Application for a Non-Material Amendment Following a Grant of Planning Permission

Town and Country Planning Act 1990
Proposed All remaining outstanding matters for plot 2 relating to DM/19/00978/OUT
At 2 Trinity Mews Durham DH1 5GG
For Mr Paul Doran
The above application received on 26 June 2023 was considered by the Council and it has been agreed that permission should be granted. I therefore enclose the appropriate approval certificate. If an application under the Building Regulations was also submitted, development must not commence until Building Regulations Approval has been received from the Building Control Division.

Minor changes to the Front Elevation (South West) window designs and size.

FIRST FLOOR PLAN

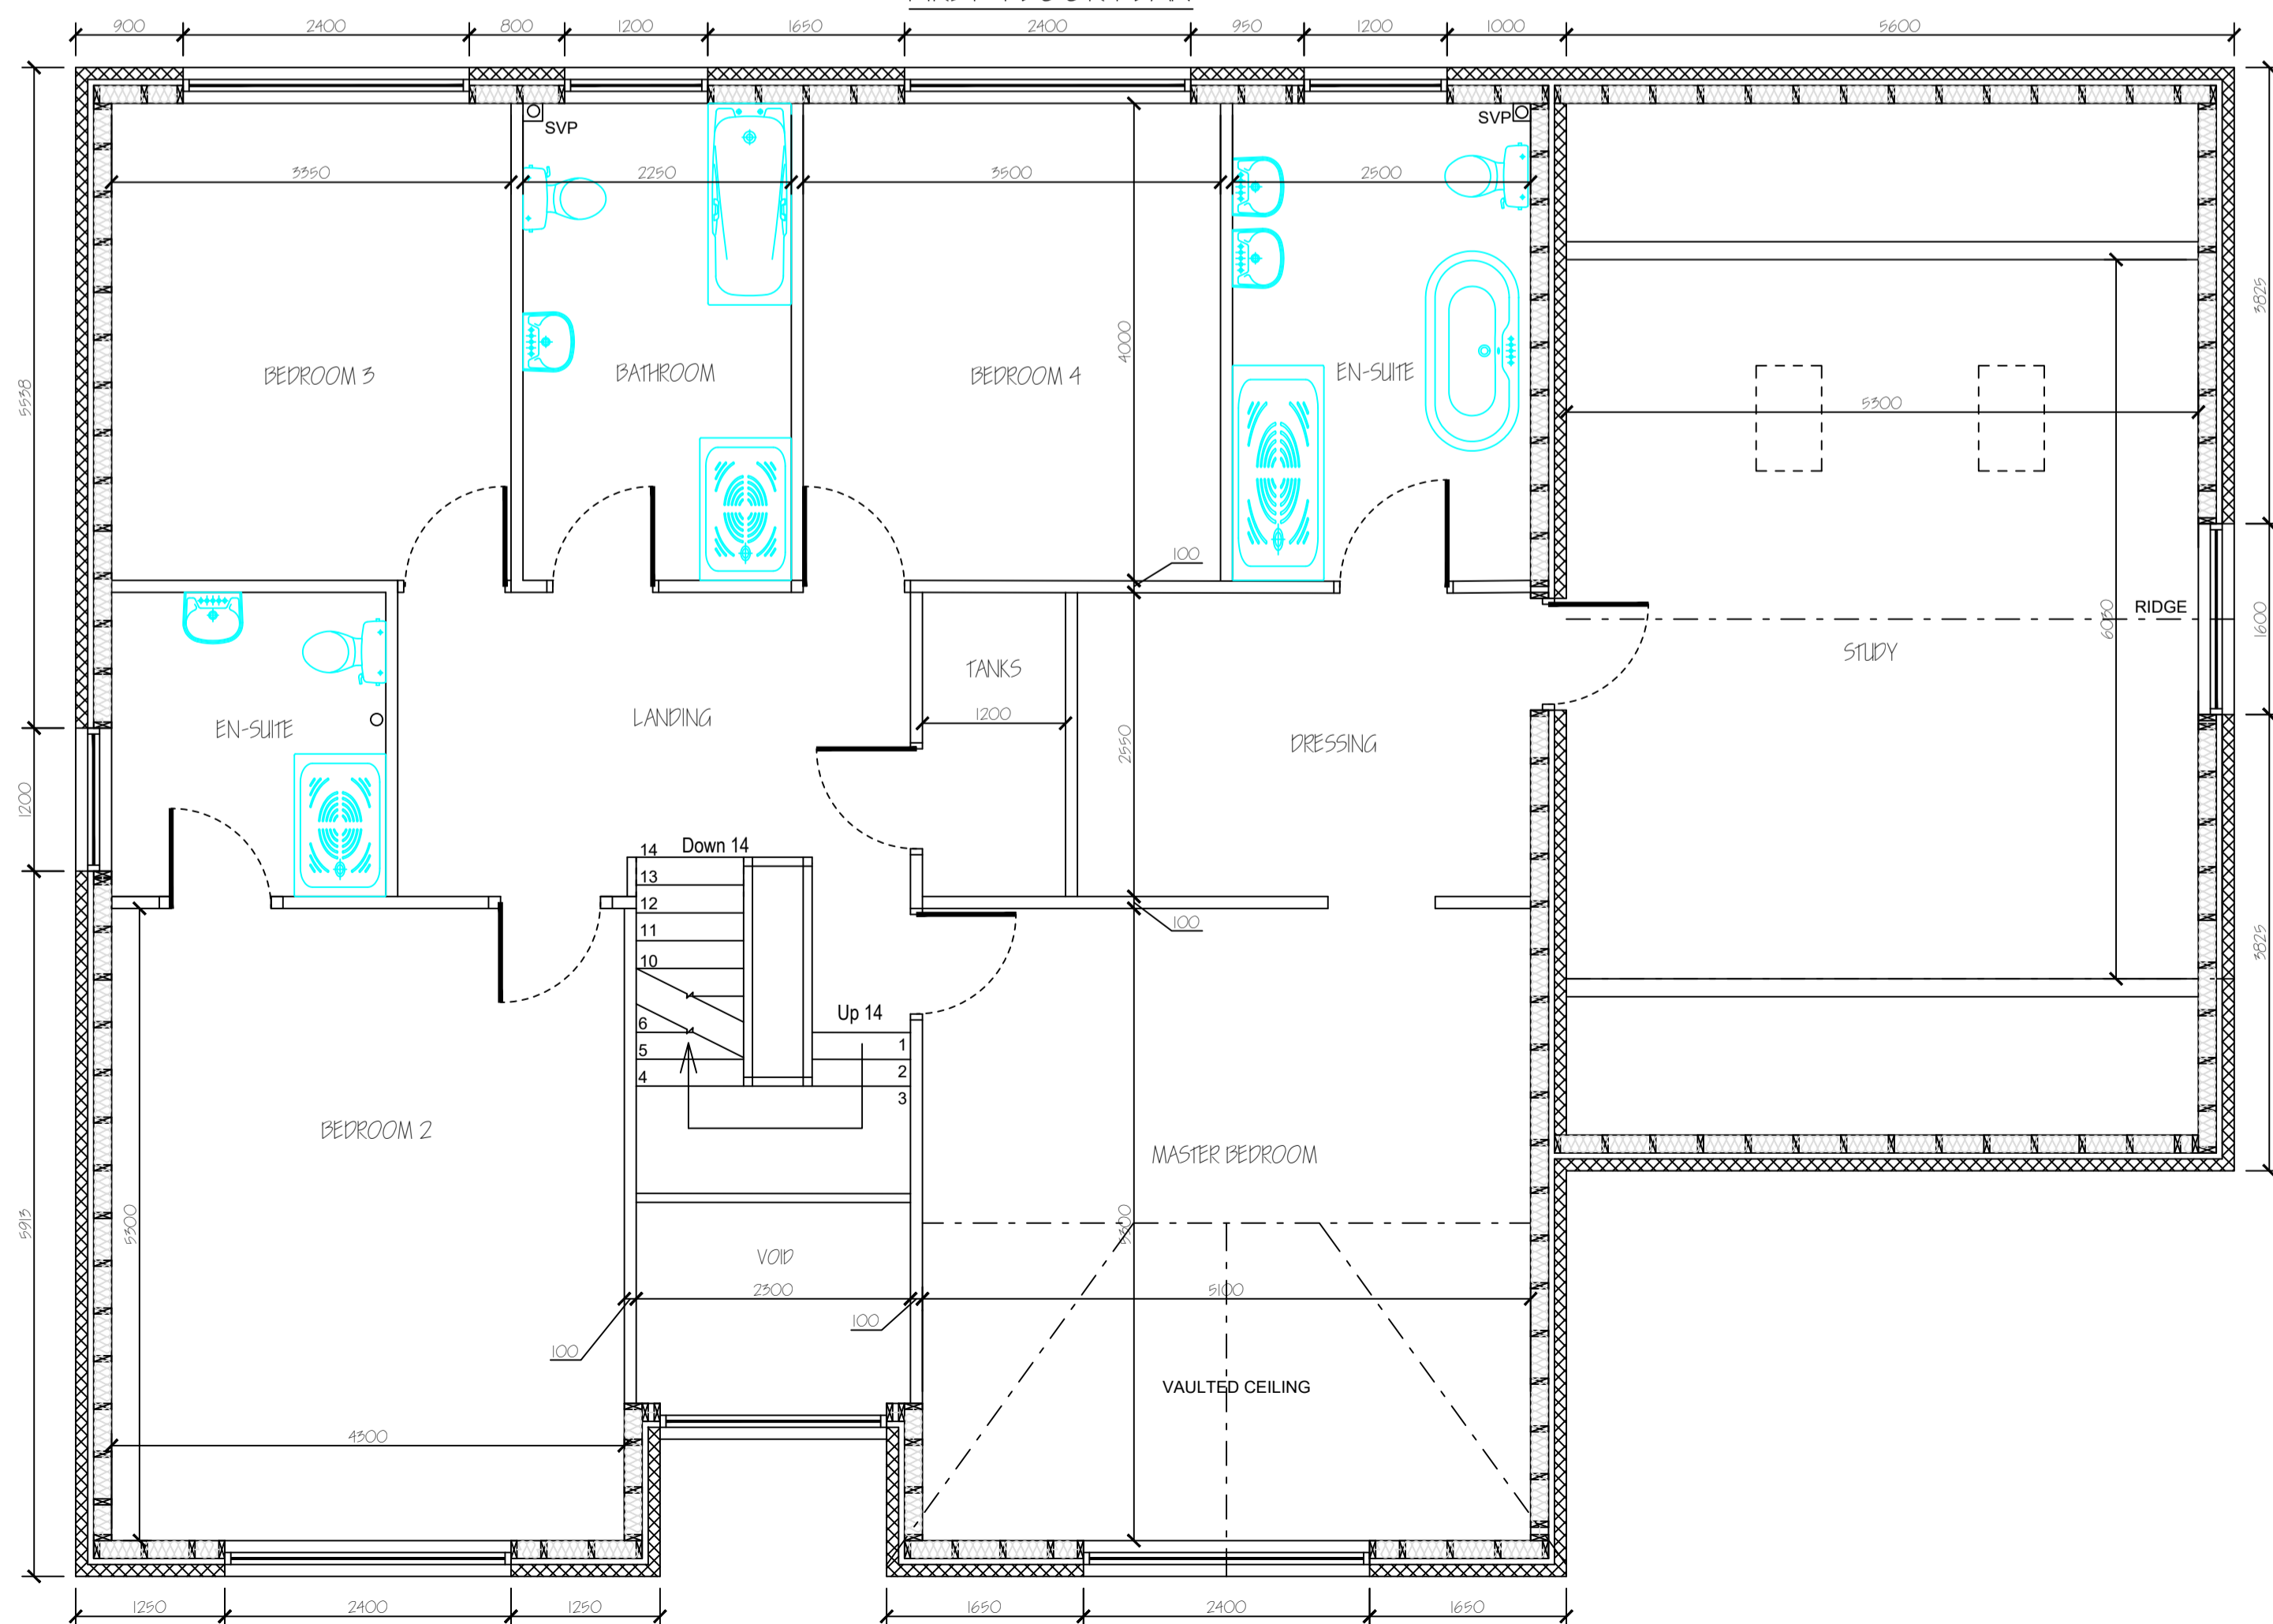
6. Remove 2 off uppermost windows on Gable Elevations, North West and South East facing.
7. Remove External rear door into Plant Room. External Rear door to Utility to remain.
